**DRAINAGE PLAN  
FOR  
WINROCK RESTAURANT SITE**

RE: DRAINAGE PLAN FOR TWO WINROCK RESTAURANT SITES (J190-D56) ENGINEER'S  
STAMP DATED 9/16/92.

**RE: WINROCK SHOPPING CENTER  
RESTAURANT SITE DRAINAGE PLAN RESUBMITTAL**

TITLE: DRAINAGE PLAN
WINROCK RESTAURANT SITES

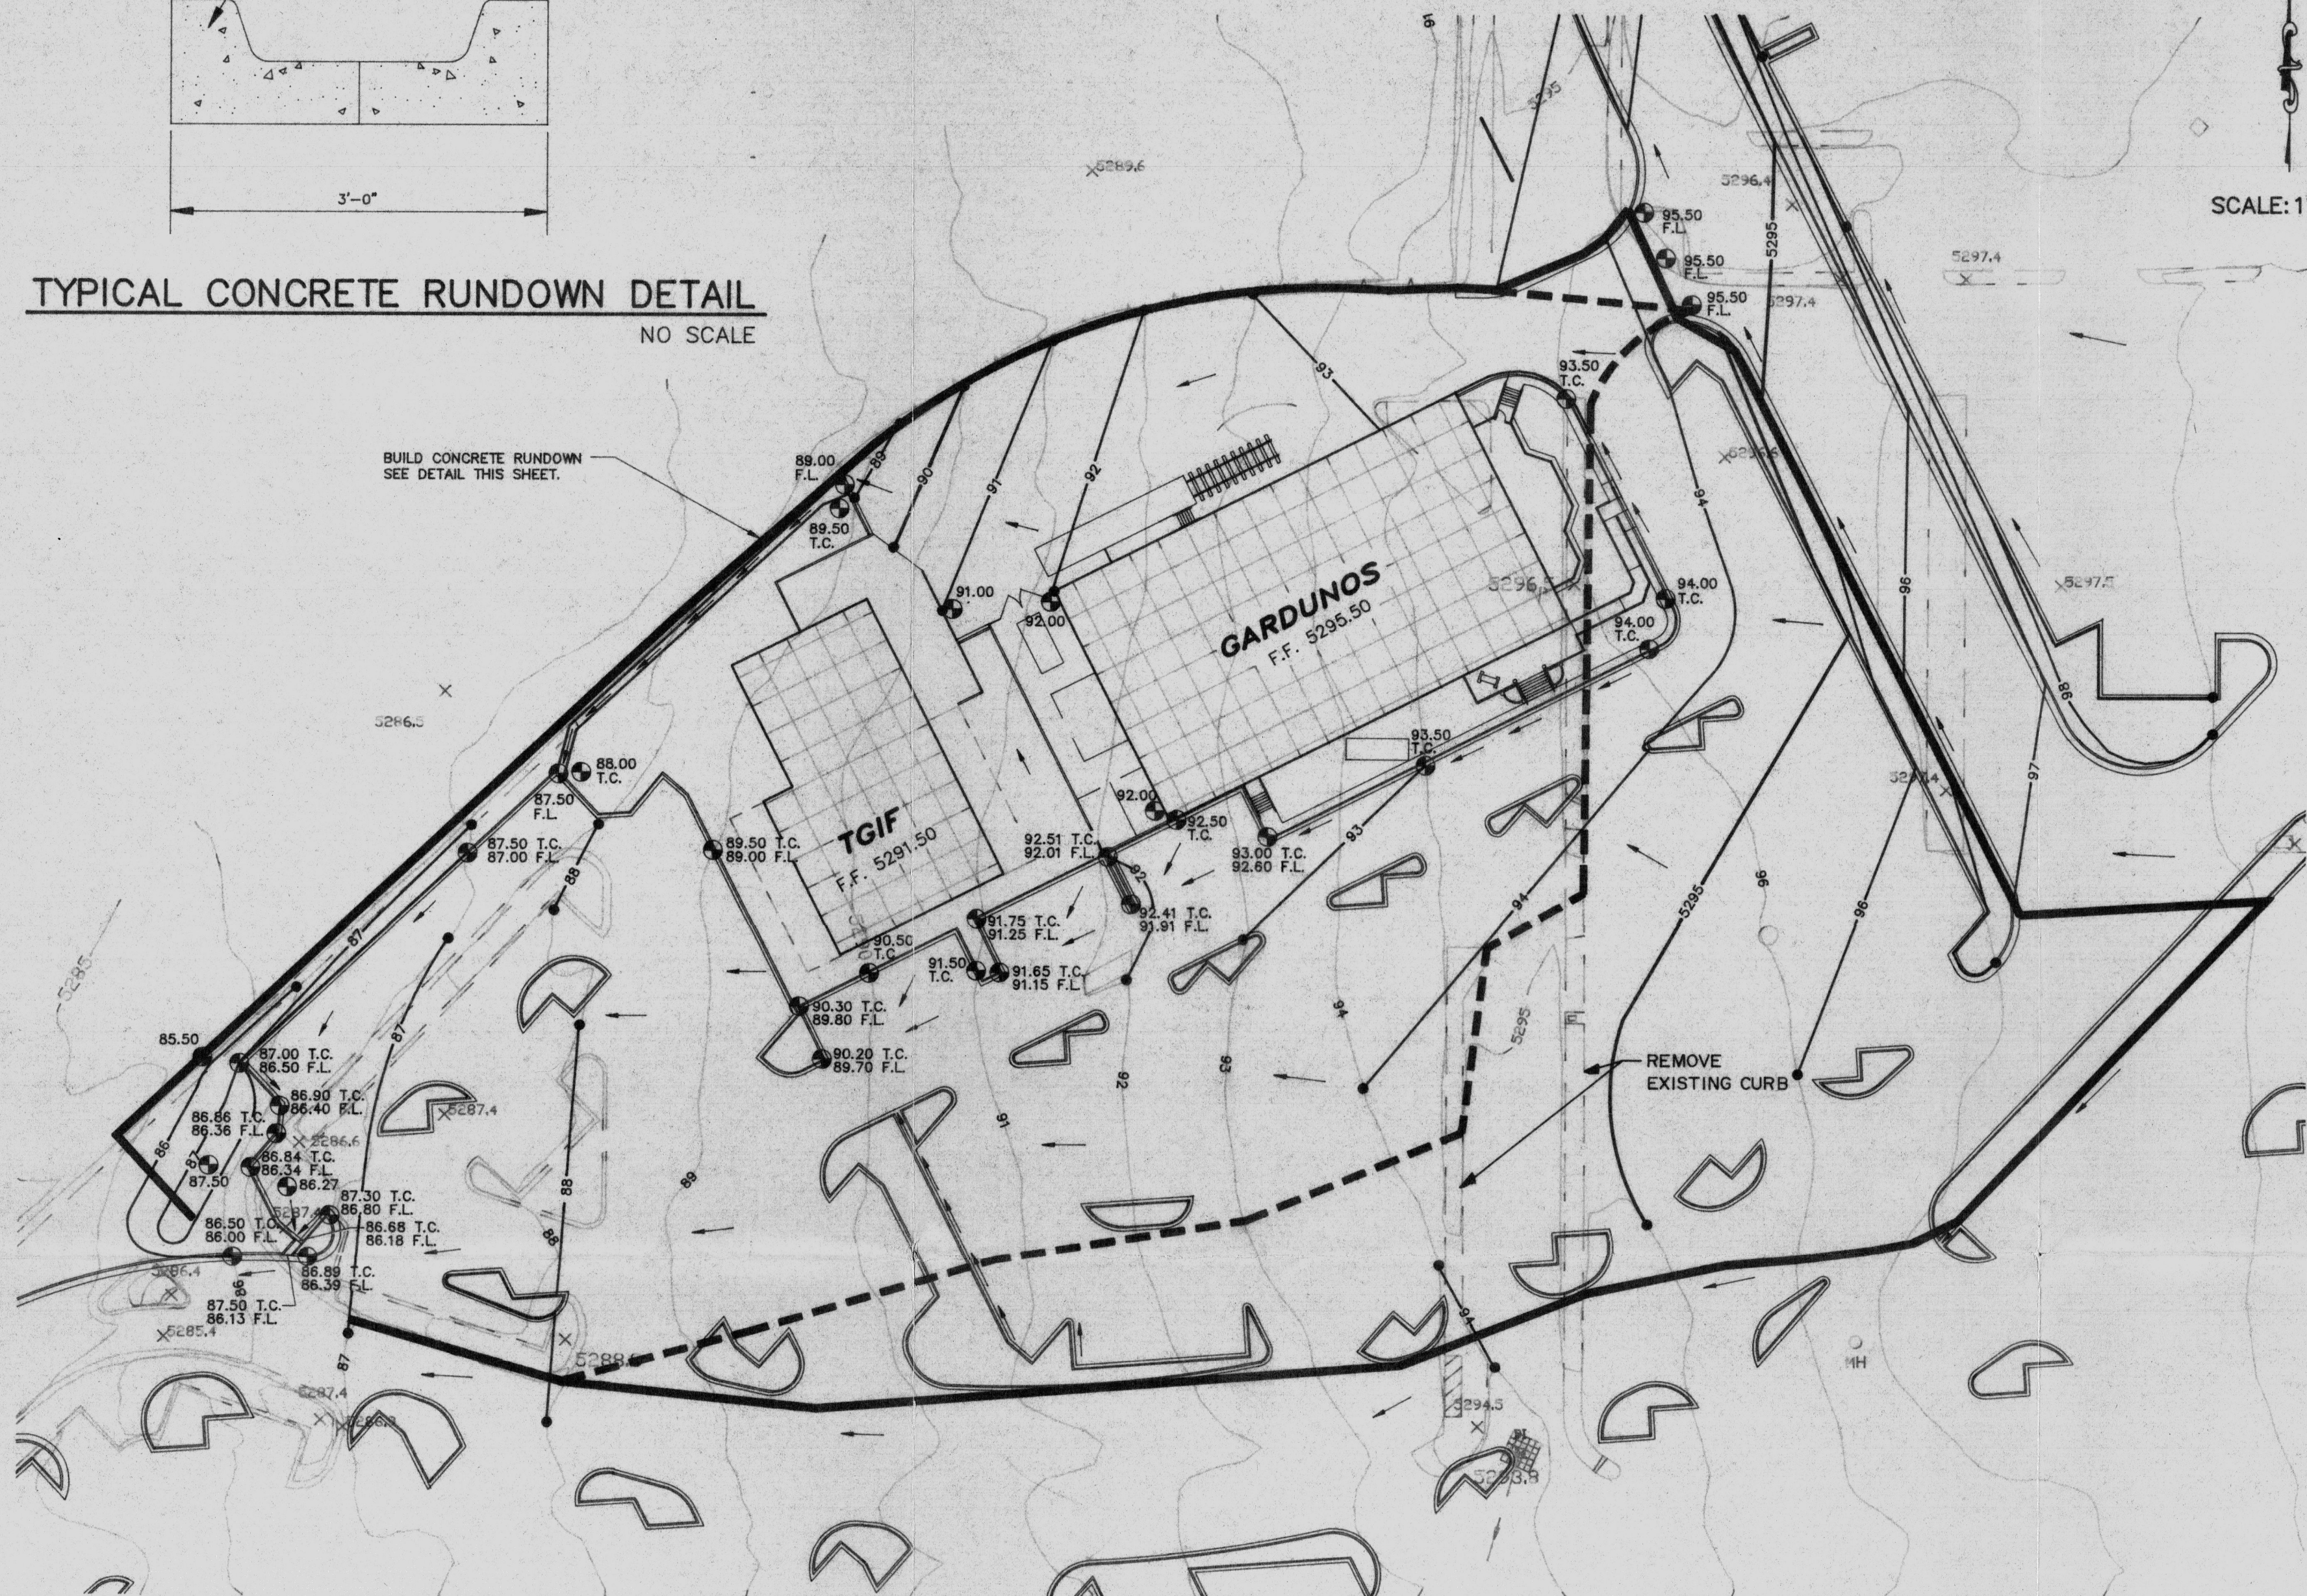
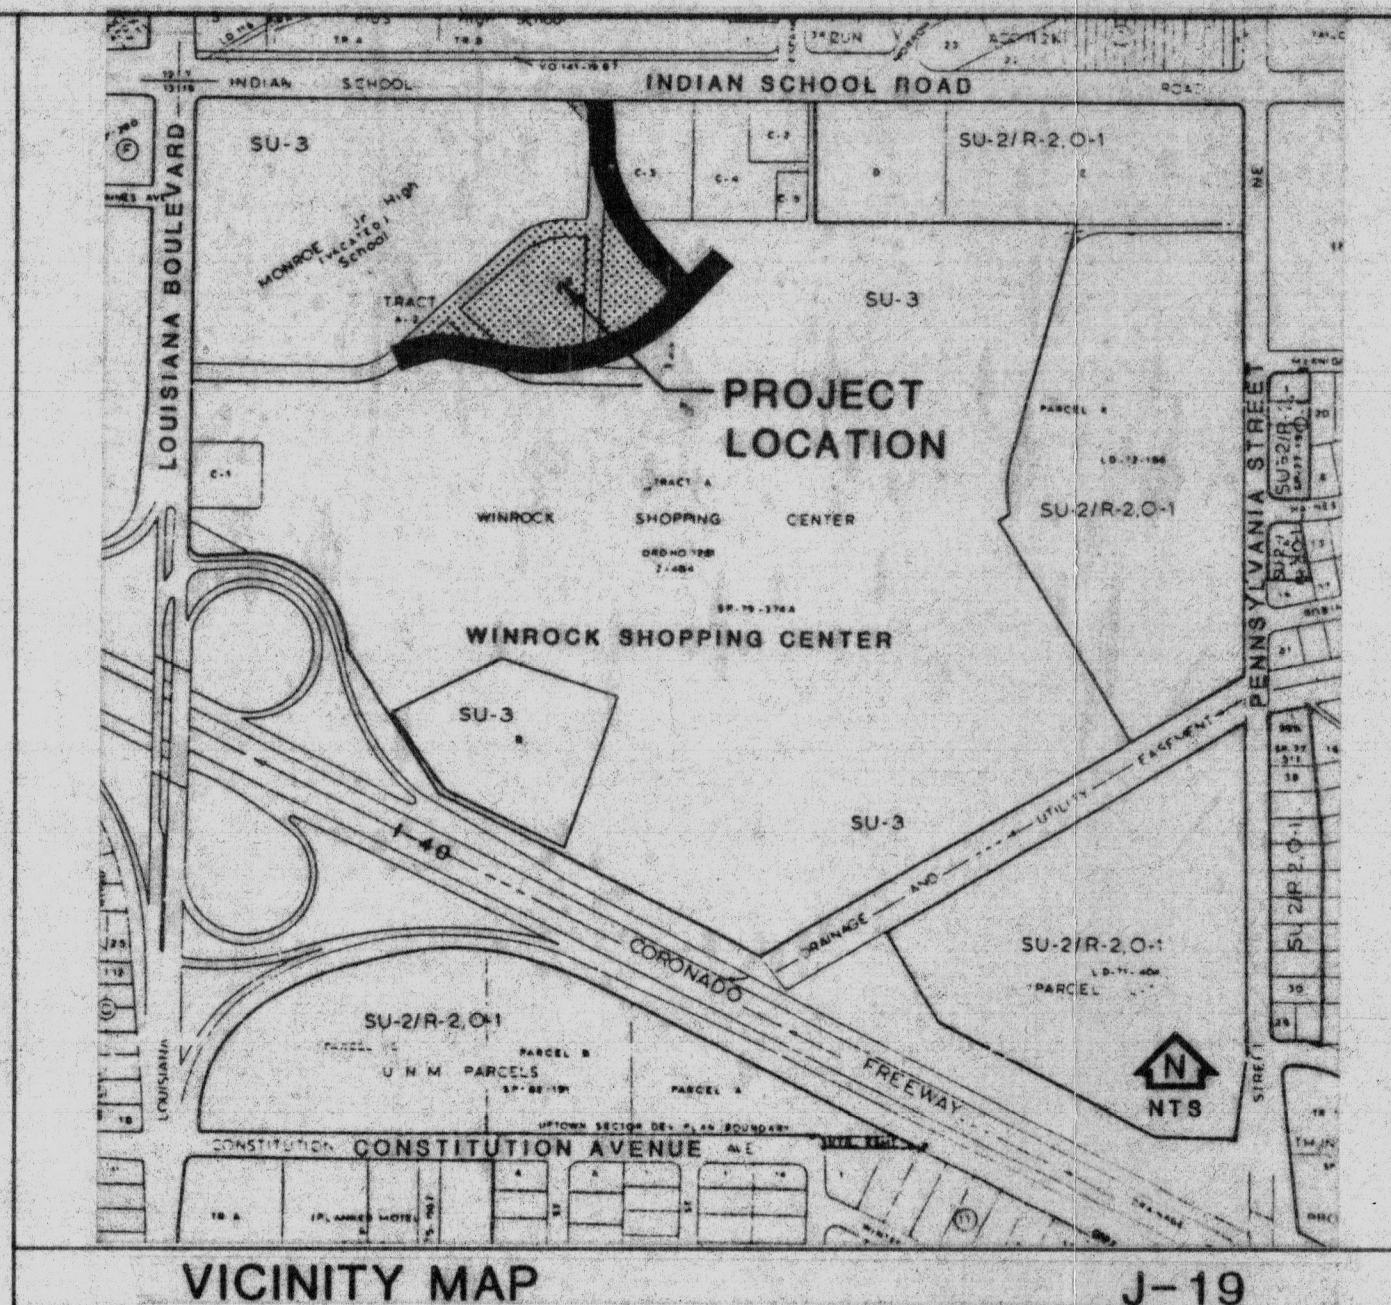
1. Will both restaurants be built under the same Building Permit?
2. Benchmarks - location, description and elevation of the:
  - A. Albuquerque Central Survey Vertical Datum used.
  - B. Temporary bench mark on-site permanently marked.
3. Flow rates - Calculations showing on-site undeveloped and developed flow rates. Flow rates will decrease with the required and landscaping.
4. Finish floor elevation must be to full mean sea level designation.
5. Location and direction of roof drains. If roof drain will be located within a landscaped area, then provisions must be provided for release of run-off onto the asphalt areas.

6. If the proposed restaurants are going to be built with separate Building Permit applications, then you may want to break up the drainage plan submittal into Phase I and Phase II.
7. I need more spot elevations around the asphalt area to show flow directions and required 1/2 % slopes.

<u>Comment No.</u>	<u>Response</u>
1.	A single approval is being sought only for the specific parking lot improvements associated with the restaurant sites. This includes the grading, paving, new curb and gutter, and pad preparation. This approval for the site is being sought separately from the approval of the building permits for the two restaurant buildings themselves.

2. Please see the bench mark notes on the plan for specific information. The bench mark listed is a New Mexico Highway Commission Monument, which has the same datum as the City of Albuquerque monuments. A temporary bench mark is also described on the plan sheet. Other temporary bench marks may be established as the project proceeds.

3. Calculations show on-site undeveloped and developed flow rates. With the proposed improvements, a section of curb will be removed that formerly directed water to the south. Without that curb, runoff from the area east of the curb will cross the site going west. That increases the size of the on-site basin. The undeveloped flow was calculated as 12.0 cfs, and the developed flow was calculated as 17.2 cfs. The increase in basin size results in a 5.2 cfs increase in runoff during the 100-year storm.

4. Finish floor elevations are shown with the full mean sea level elevations. The elevations are high enough above the surrounding ground level to prevent flooding the restaurants during the 100-year storm.

5. See General Note No. 3 on the plan.
6. See Response 1.
7. Spot elevations are shown in critical areas around the asphalt to provide minimum 0.5% slopes. Proposed flow directions are also indicated on the plan for clarity.
